ENG-PUDSP21001-R1-PDR-Redlines.pdf Markup Summary

PUDSP-21-001

THE VILLAS AT
 CLAREMONT RANCH
 PROPOSED DRAINAGE
 MAP

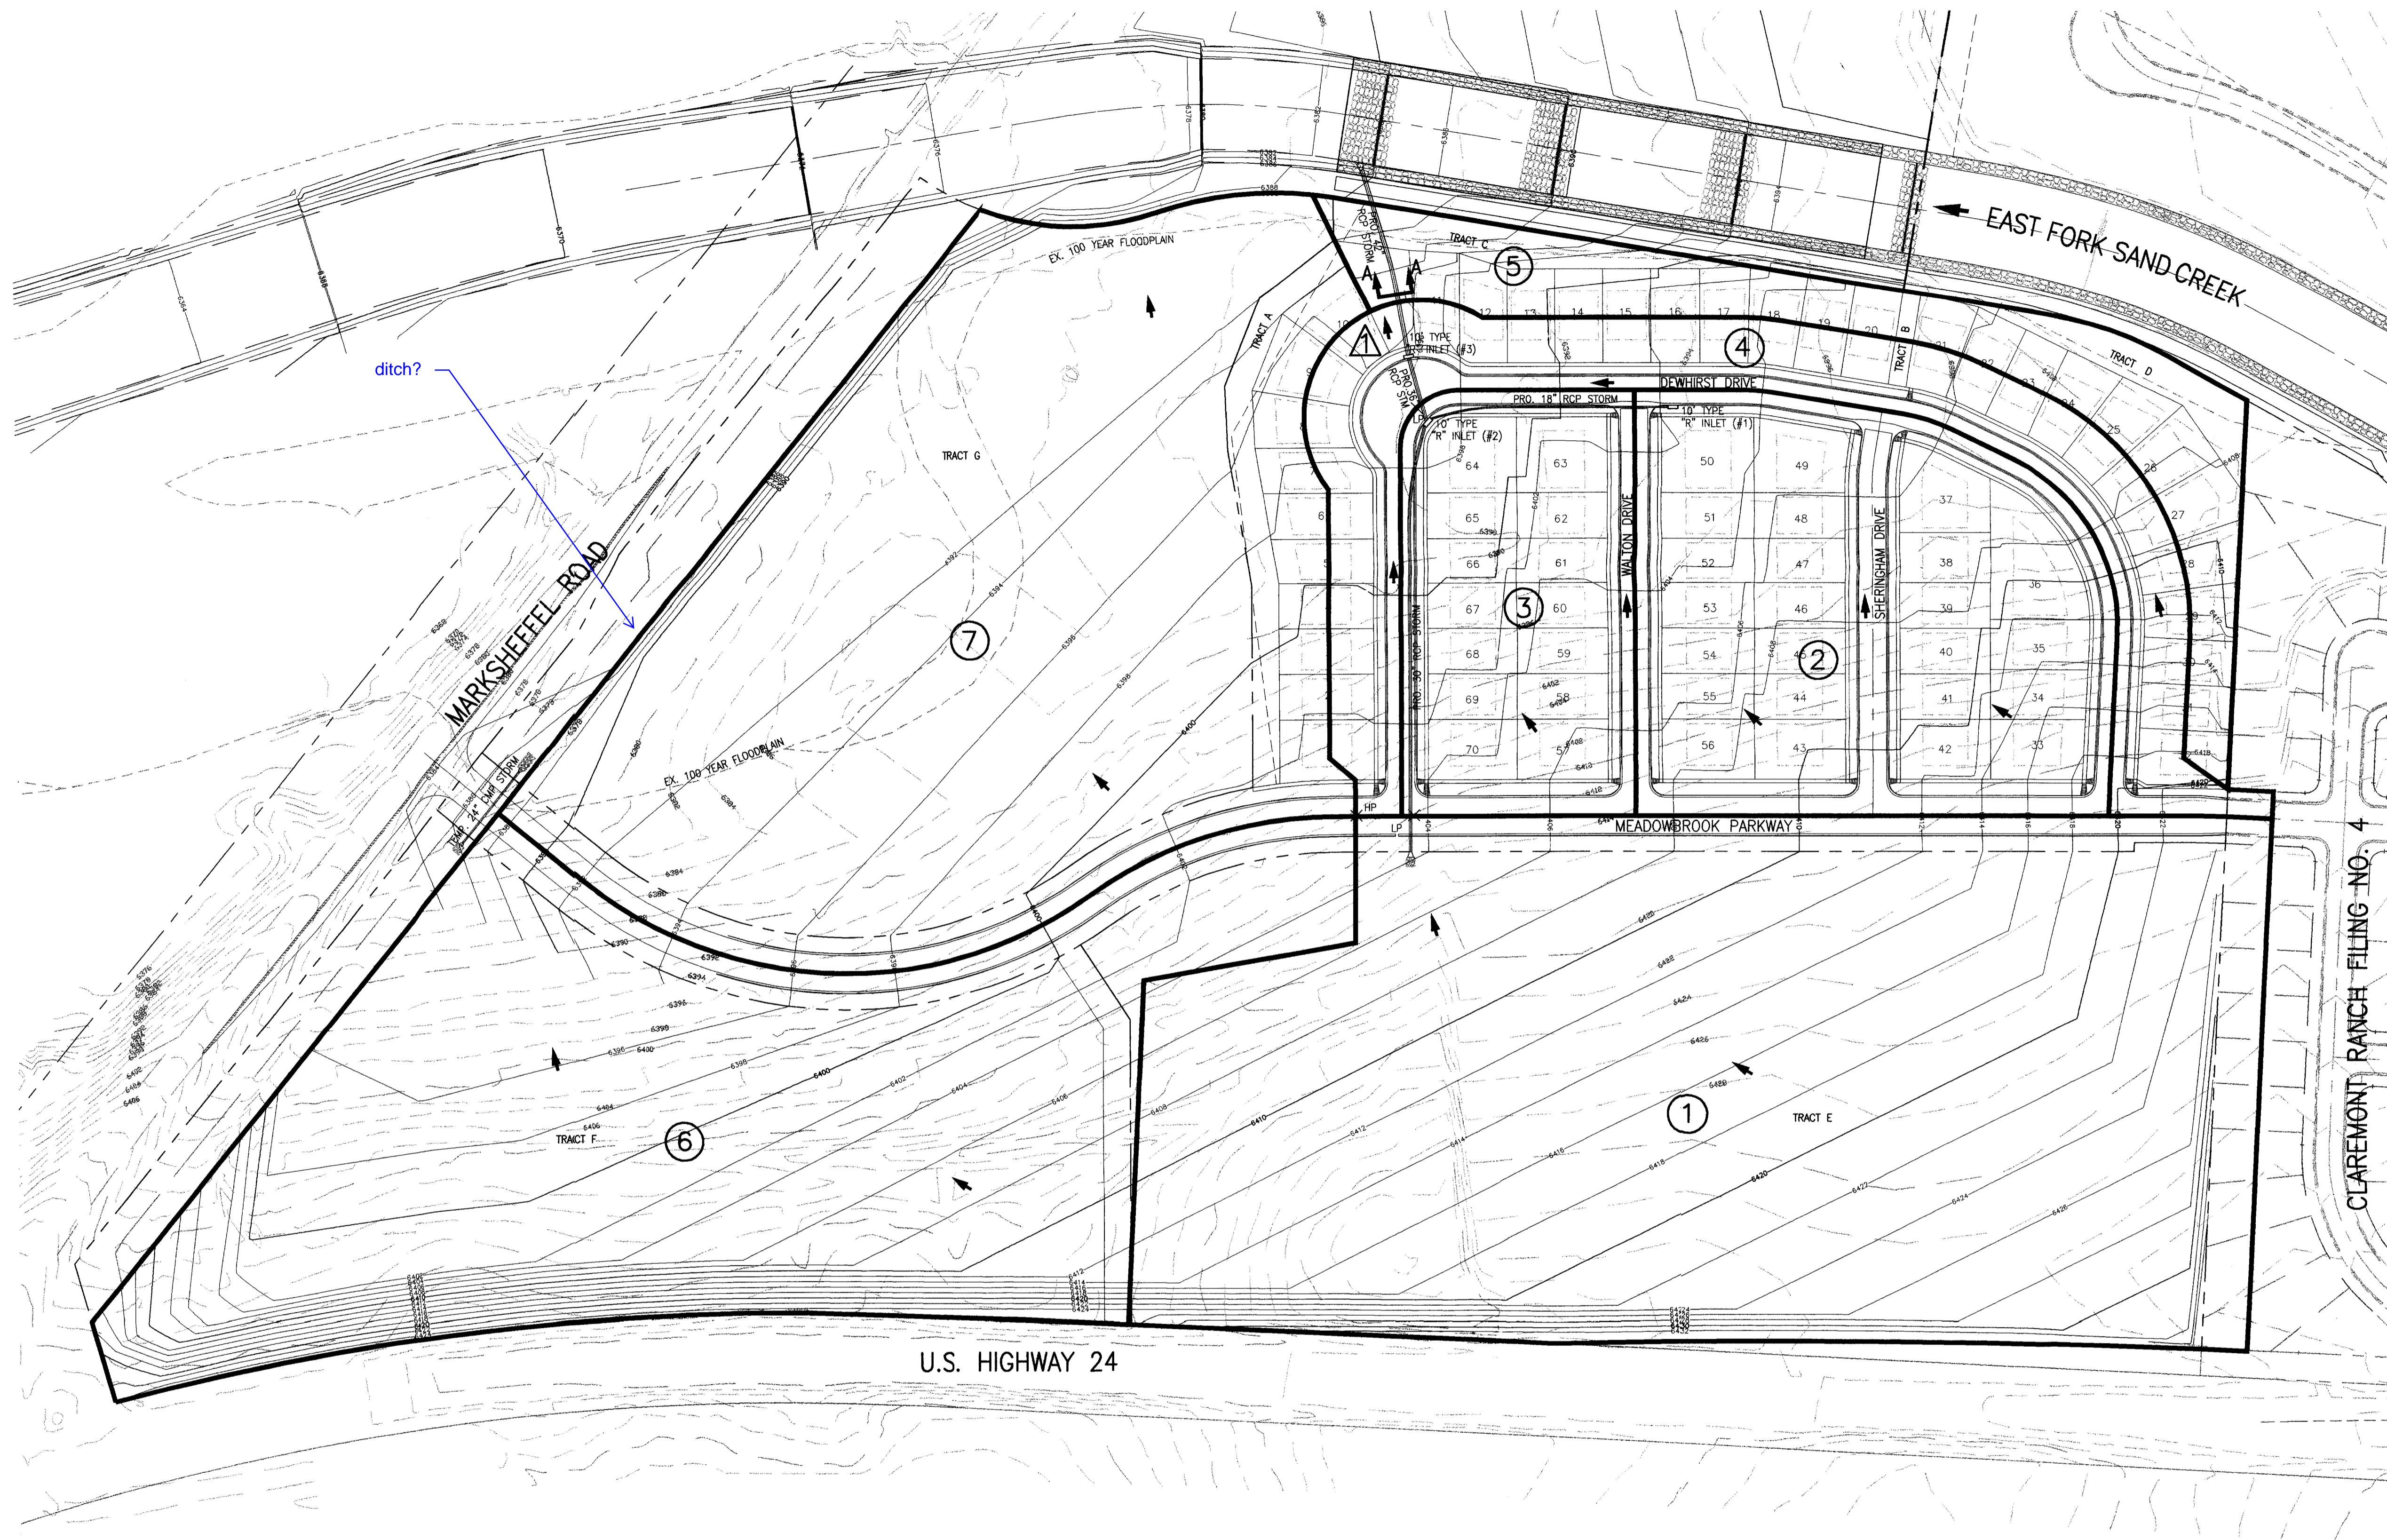
Show and label manhole

Show and label all easements

Clearly show all maintenance access roads required.

A standard forebay design is required.

Sidewalk chase?

Inundation area at 92

Label spillway elevation

Show and label trail and proposed spillway material over the trail and to the bottom of the channel.

Inundation area at FSD spillway overflow?

Provide a table with pond attributes (outlet and spillway elevations, water depths and volumes at WQCV, EURV, 10- and 100-year storms, etc.).
